TRAFFIC IMPACT STUDY

Owl Place Commercial
El Paso County, Colorado
PCD File No. CR221

June 2022

April 2023

# OWL MARKETPLACE FILING NO. 1

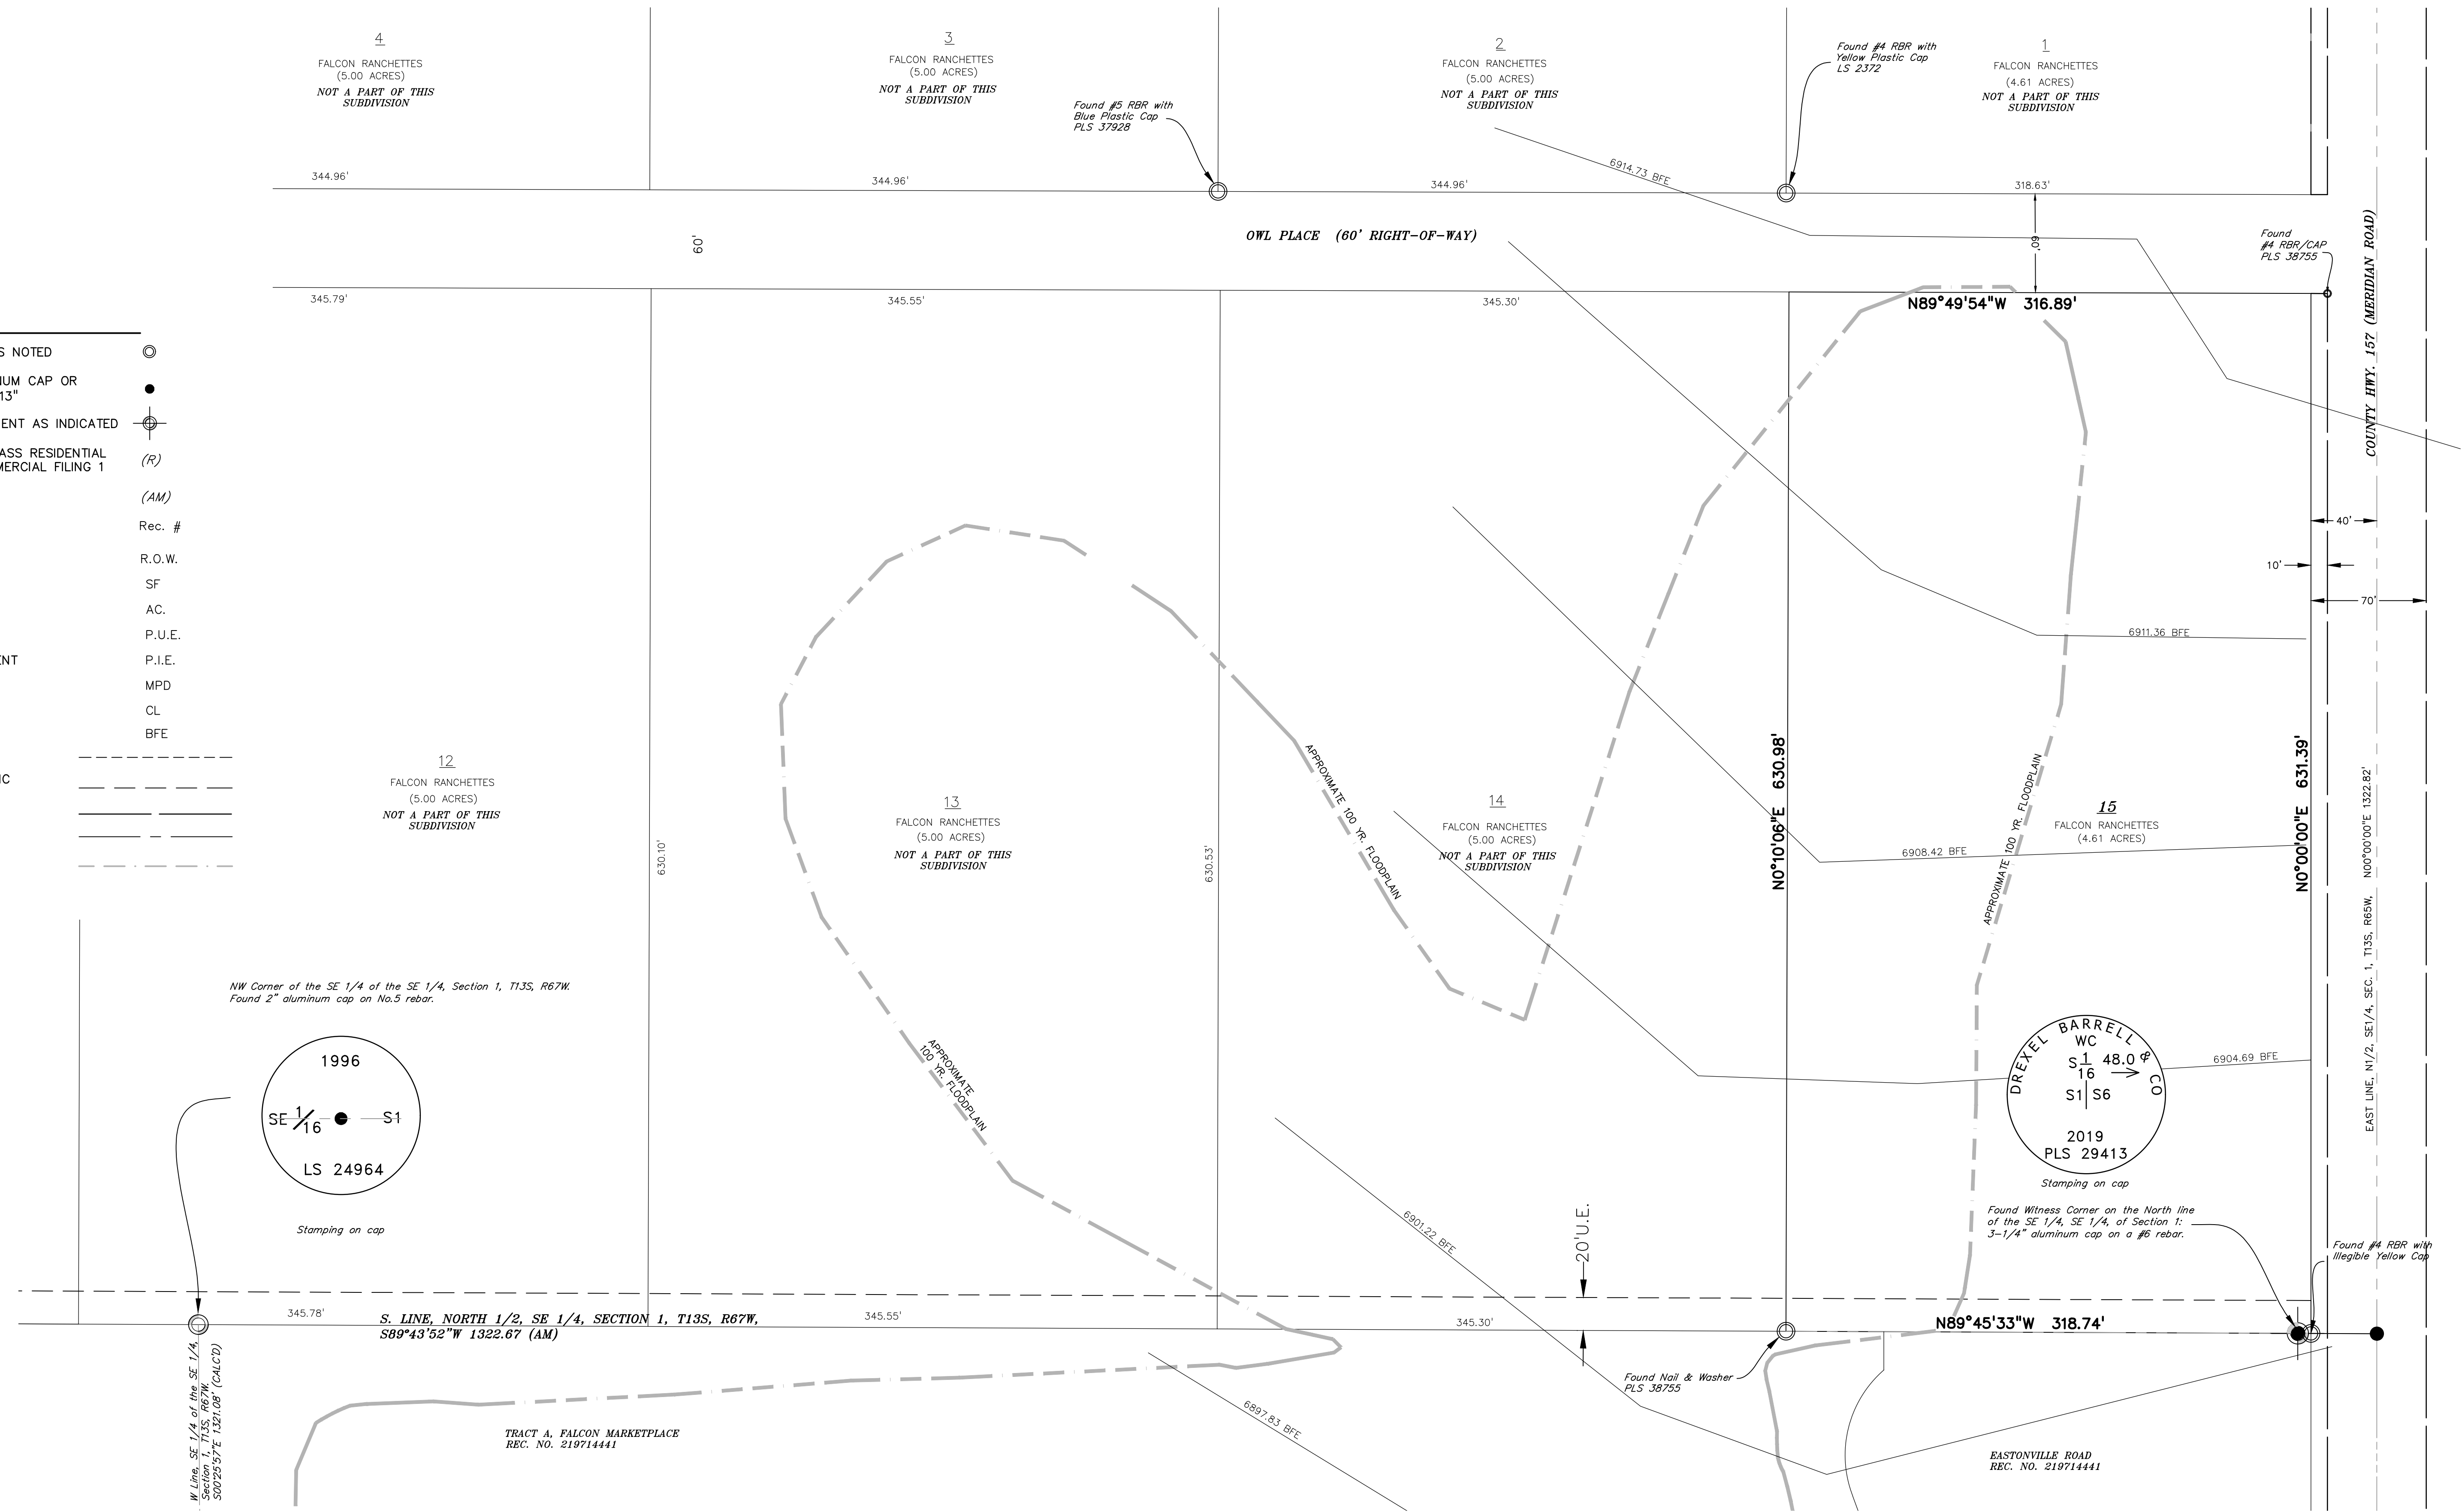
Address sight distance and access spacing for all entrances to lots

Address access spacing from Round about to Lot #1
